Appeal Decision

Appeal Ref: APP/R5510/Z/25/3374976

Jubilee Place, 6 High Road, Ickenham, Middlesex UB10 8LJ

- The appeal is made under Regulation 17 of the Town and Country Planning (Control of Advertisements) (England) Regulations 2007 (as amended) against a refusal to grant express consent.
 - The appeal is made by Mr Alvin Osei-Tutu of Bluebird Care against the decision of the Council of the London Borough of Hillingdon.
 - The application Ref is 79593/APP/2025/1961.
 - The advertisement proposed is installation of a non-illuminated freestanding sign.
-

Aluminium composite (dibond) panel  
with printed gloss vinyl sticker

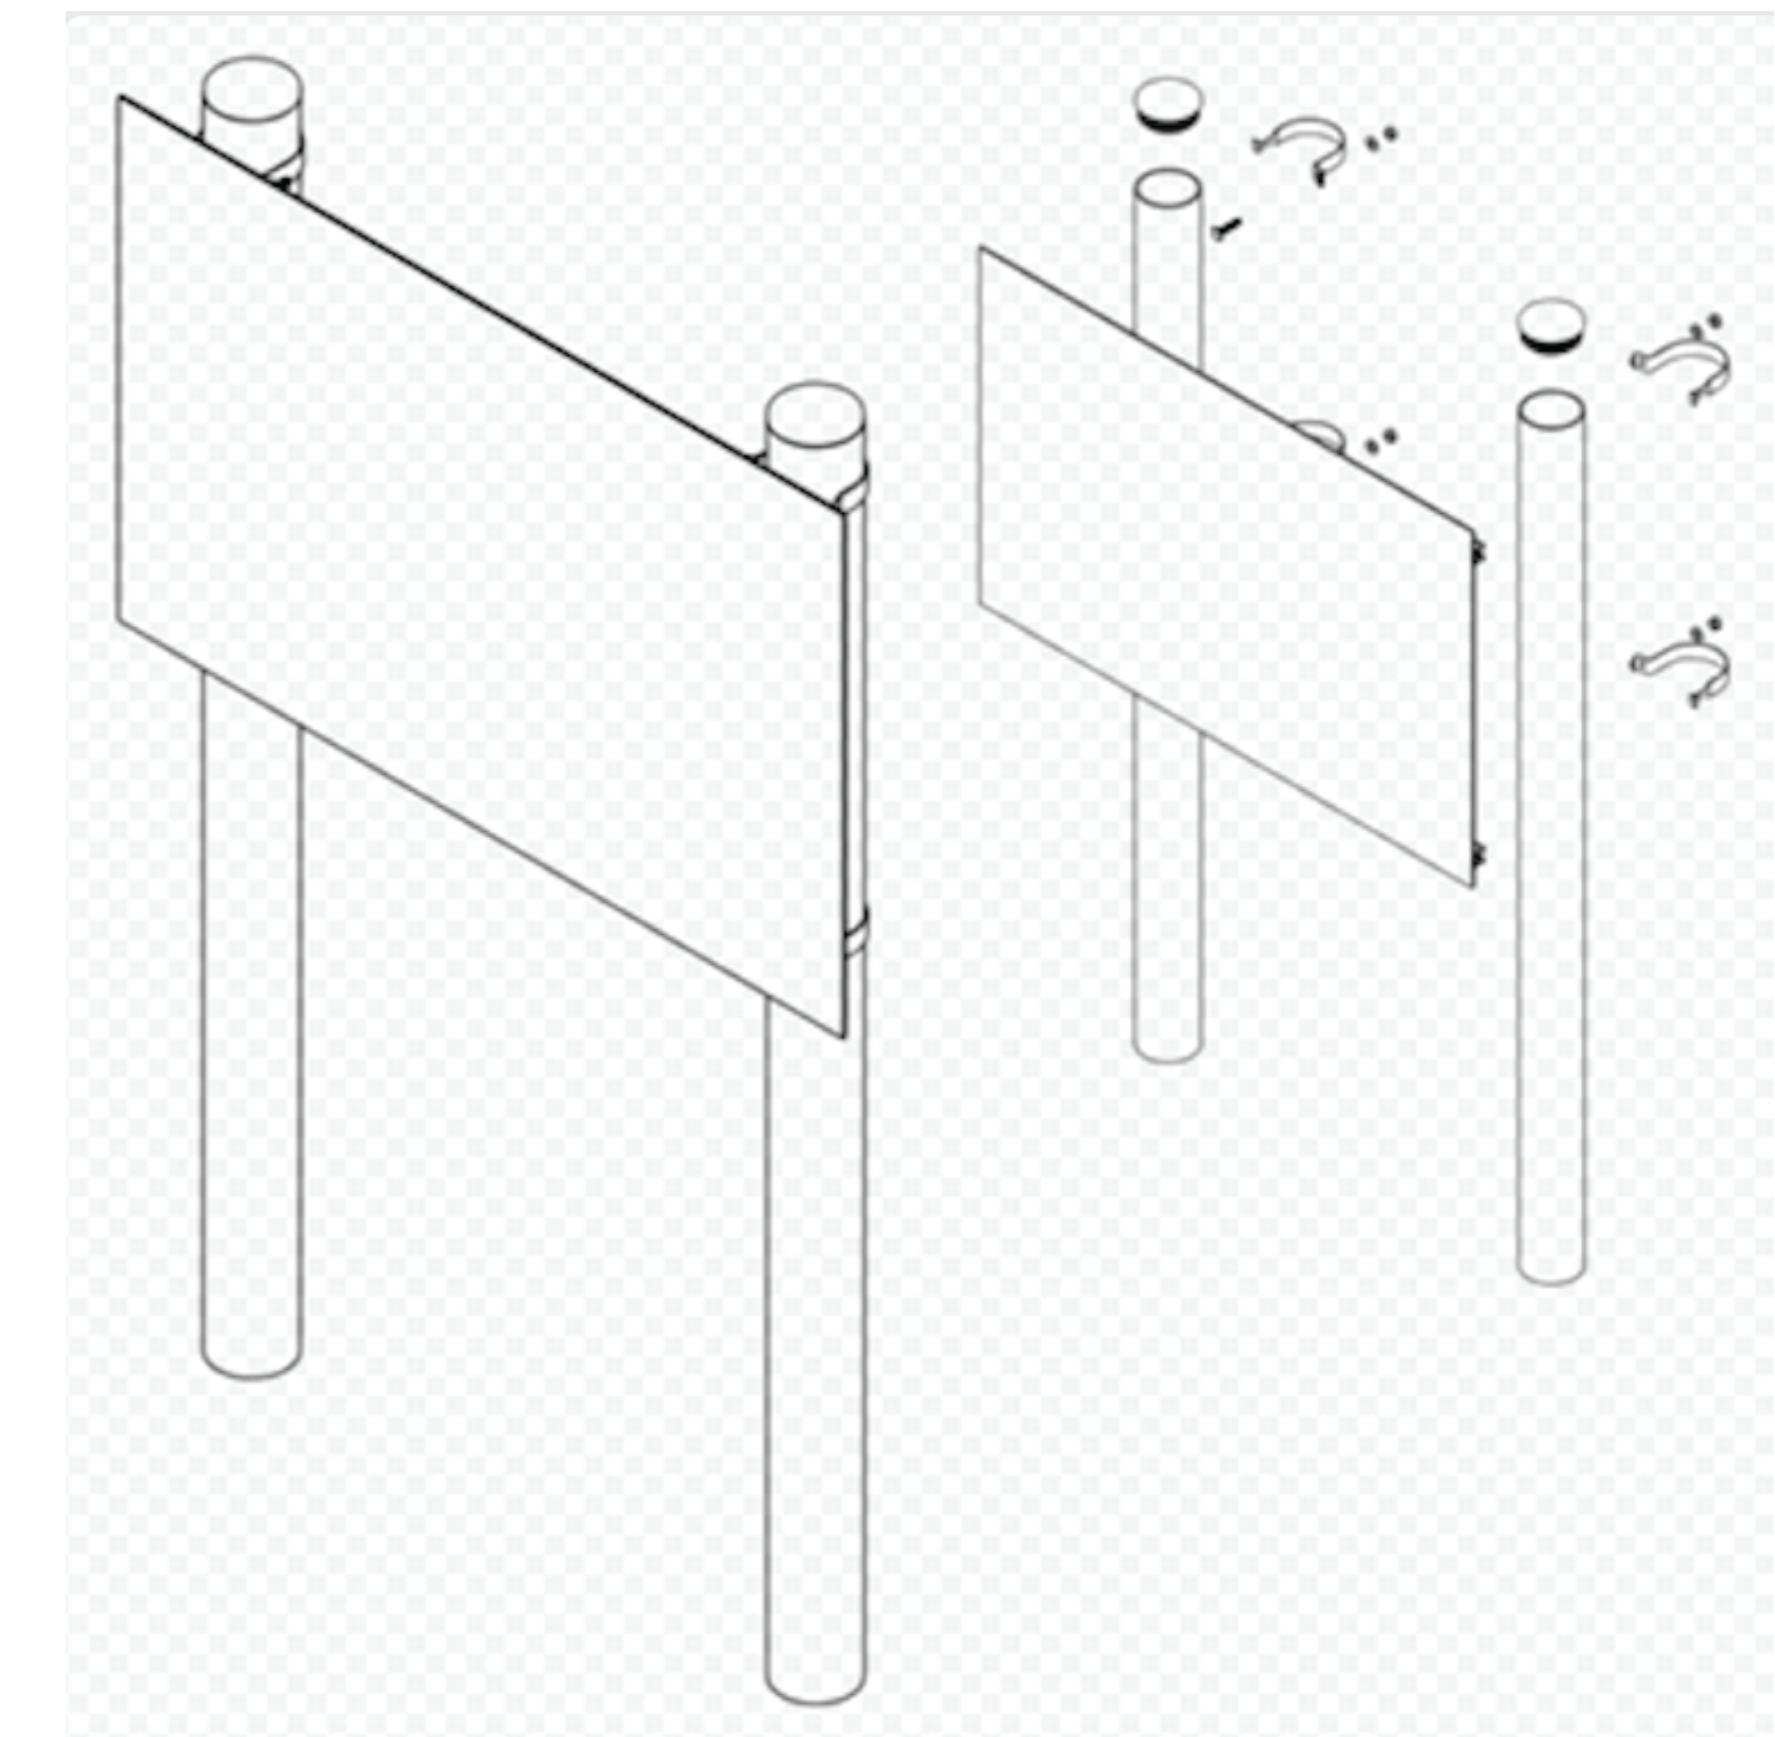
12. The appeal sign is an aluminium composite panel with applied sticker on metal supporting poles. Given the variety of materials used in signs nearby, I am satisfied that the materials are appropriate to the context. The poles are of a utilitarian appearance but are modest in size and fairly inconspicuous in their context.

13. The sign panel, however, occupies a prominent position within the streetscene. Due to its scale and siting, it obscures a significant part of the front elevation at No.6, including its ground floor windows. This obtrusive appearance detracts from the architectural composition of this non-designated heritage asset and the contribution it makes to streetscene and the significance of the IVCA and the immediate setting of the adjoining No.4 and No.10, resulting in harm to these heritage assets. Whilst I do not doubt that the design and choice of colours benefited from professional input, this does not mitigate the harm that I have identified.
